Our Case Number: ACP-324383-26

Re: Proposed IDA Belview Infrastructure Development
Belview, Slieverue, County Kilkenny

SUBMISSION TO AN COIMISIÚN PLEANÁLA

Application: IDA Belview Infrastructure Development, Belview, Slieverue,
County Kilkenny (Section 177AE)
Submission by: Garry Mentanko
Date: July 25, 2026

Title: **Proposed Access Road Layout Sheet 1 of 2**

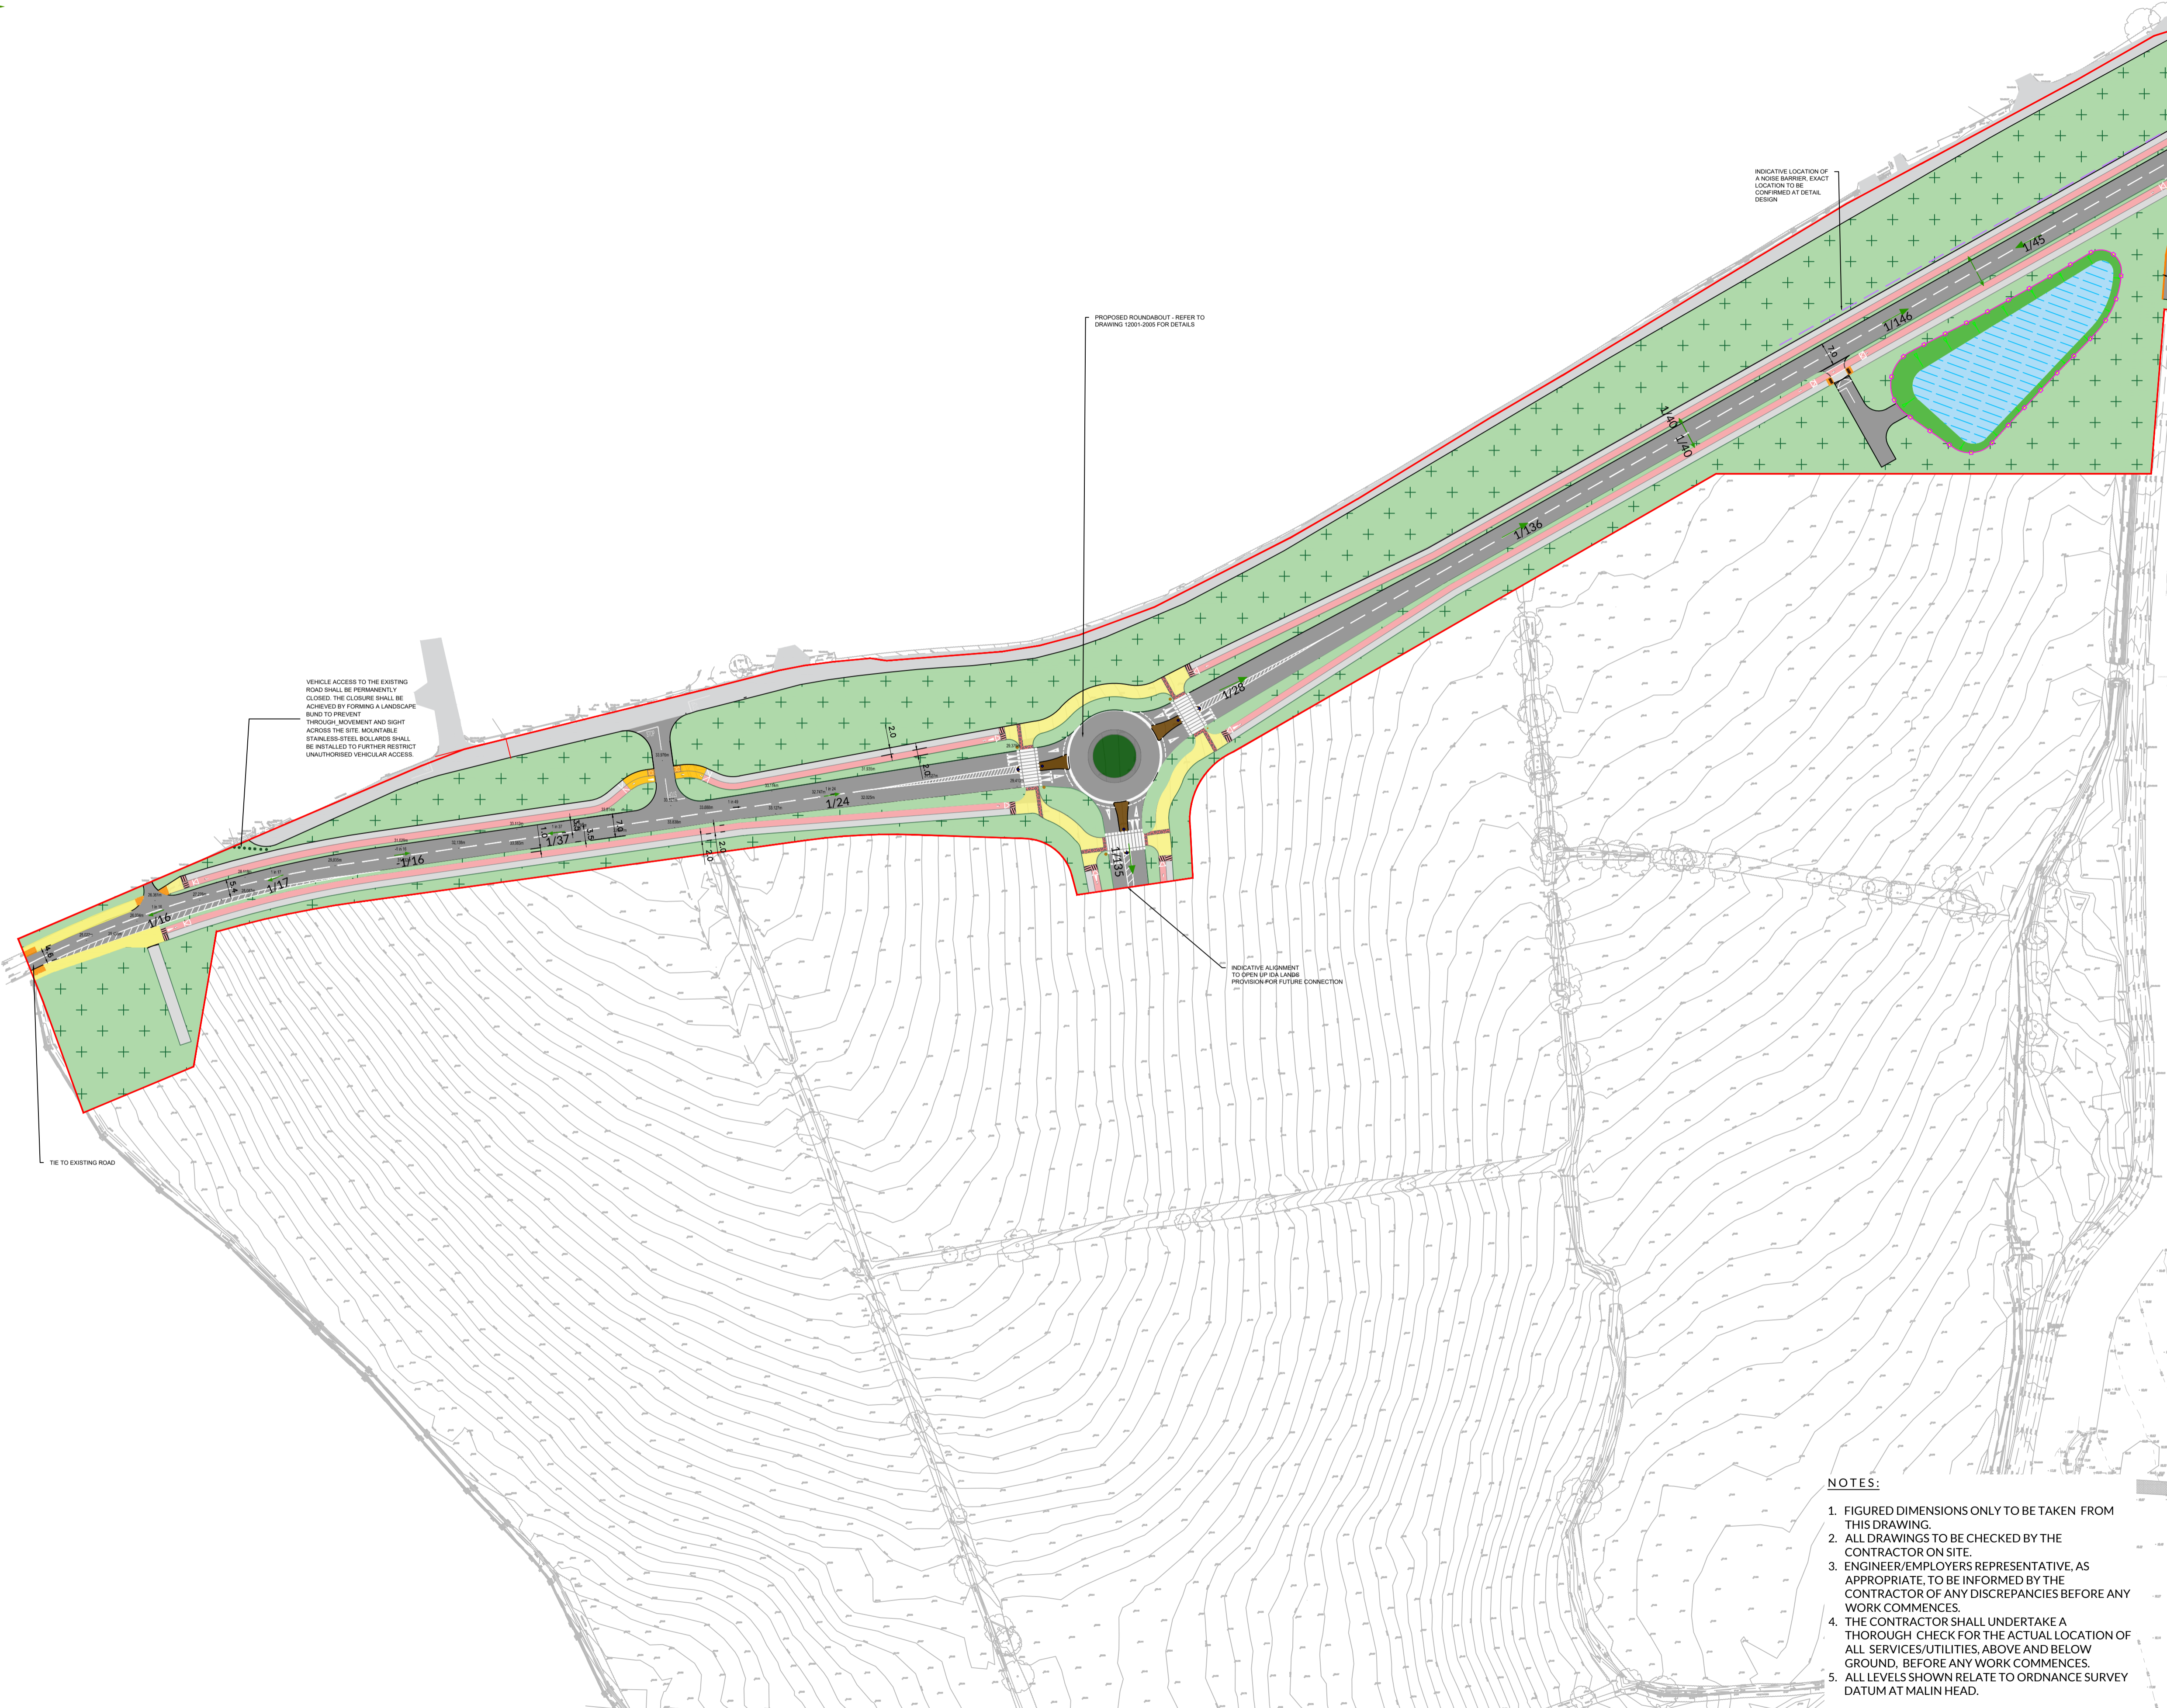
Finally, I have concerns as to the access that the public will have to on both ends of the proposed closed L3412. Unless this is managed early, there remains the possibility of people parking up on either end. I would like to see some referece to preventing this as well as how it will be prevented in the future when the works are completed.
